6 July, 2016

Your ref: MP 06_0228 (Mod. 9)

**RE: SHOALHAVEN STARCHES EXPANSION PROJECT – MP06_0228
MODIFICATION TO PACKING PLANT (MOD. 9)
BOLONG ROAD, BOMADERRY**

Under-bore pipes under Bolong Road

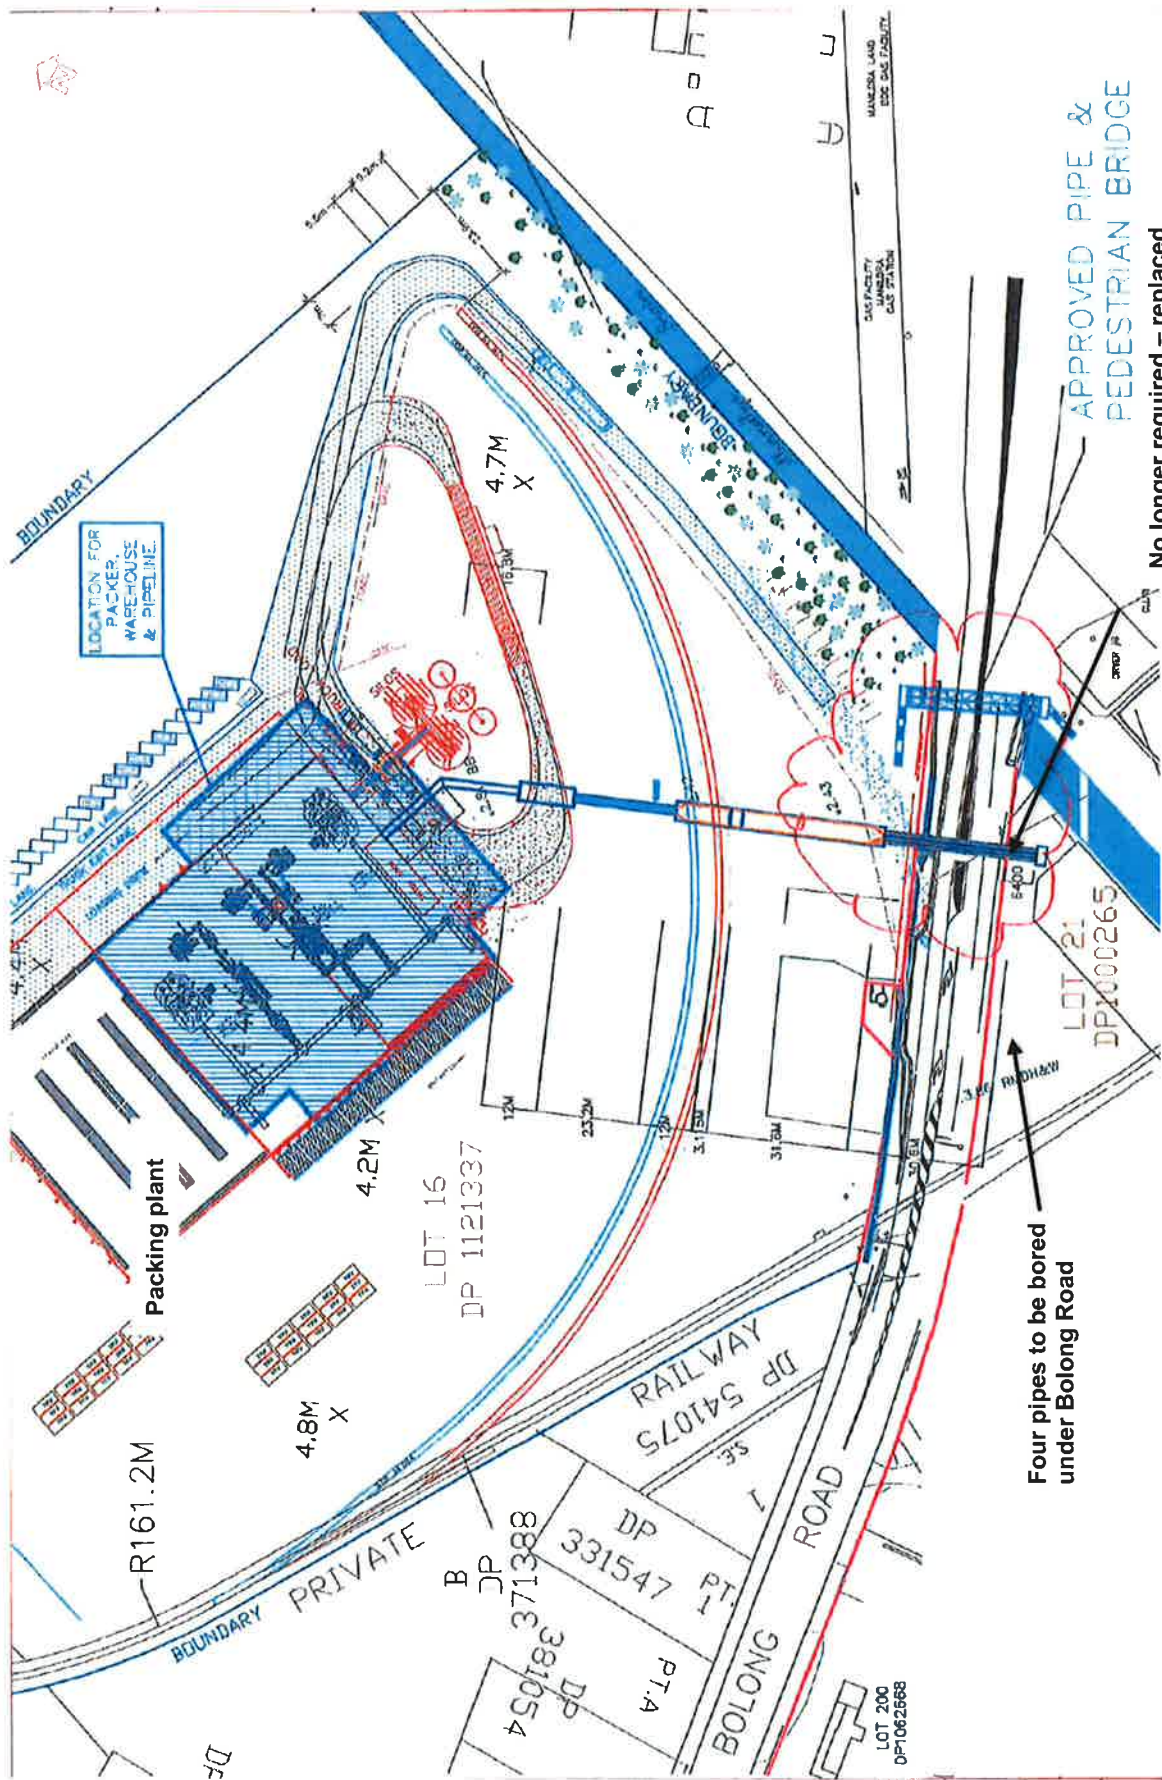
- *Can you please provide me with some evaluation of pedestrian movements across Bolong Road between the factory and new packing plant, in light of removing the pedestrian/pipe over bridge over Bolong Road. Some estimation of pedestrian movements and safety, for inclusion in our assessment.*
- *Can you also confirm if there are 5 or 7 storage silos at the new packing plant, the EA and appendices differ. Can you also confirm the height of each silo. Is the 34.3m high structure a silo or gantry or building enclosure?*

“... pedestrian movements across Bolong Road will be managed, if the pipe bridge is no longer required.”

This included the construction of a pedestrian refuge (pursuant to condition 30 Schedule 3 of the Project Approval) located centrally within the Bolong Road reserve adjacent to the location of the proposed underground pipework (refer **Plate 1** below). This refuge is already used by Shoalhaven Starches staff to cross Bolong Road. It is envisaged that pedestrians would continue to be able to cross at this point using the existing pedestrian refuge.

Once commissioned the new Packing Plant on the northern side of Bolong Road will generate minimal pedestrian movements across Bolong Road. Staff employed on the Packing Plant site will not need to cross the road on a regular basis given the nature of the work undertaken on the site; and as this site will be self-sufficient in terms of on-site car parking. A purpose-built staff car park comprising 30 parking spaces will be located adjacent to the new Packing Plant building to be used by staff employed on this site.

In reality during operations there will in fact be very few occasions when staff will need to cross from the Packing Plant to the factory sites. Staff employed on the packing plant site will not need to cross the road to the factory site. Only a Production Manager employed on the factory site will need to cross to the Packing Plant site possible twice per 12 hour shift to monitor staff within the Packing Plant site.

Given the above circumstances, and given the distance separation between the packing plant and factory site, it is unlikely that there will be many pedestrian movements between the factory site and the packing plant site across Bolong Road. It is highly likely that when staff are required to visit the packing plant site that such visits will be by vehicle rather than by foot.
